Please ask for: Mrs D Johnson
Email: daun.johnson@arun.gov.uk
Telephone: 01903 737762
Our Ref: LU/115/20/PL
Your Ref:
Date: 13th May 2020

Application for Planning Permission

Development: Retrospective planning application for minor external alterations comprising the position of the bin storage area, external storage container and condenser enclosure.

Location: 5 Arundel Road Littlehampton BN17 7BY

ELEVATIONS
1:100@A3

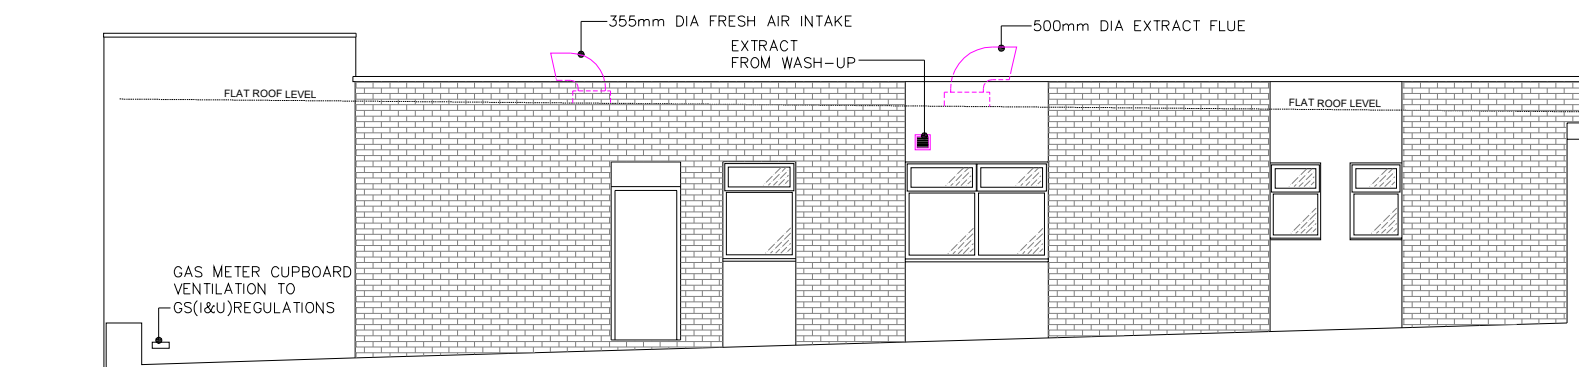
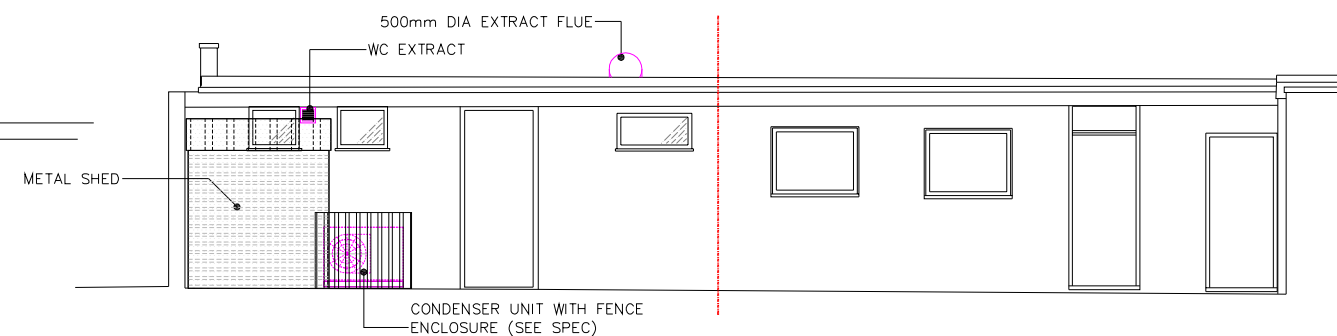
Please provide the north, south and east elevations of the metal shed.
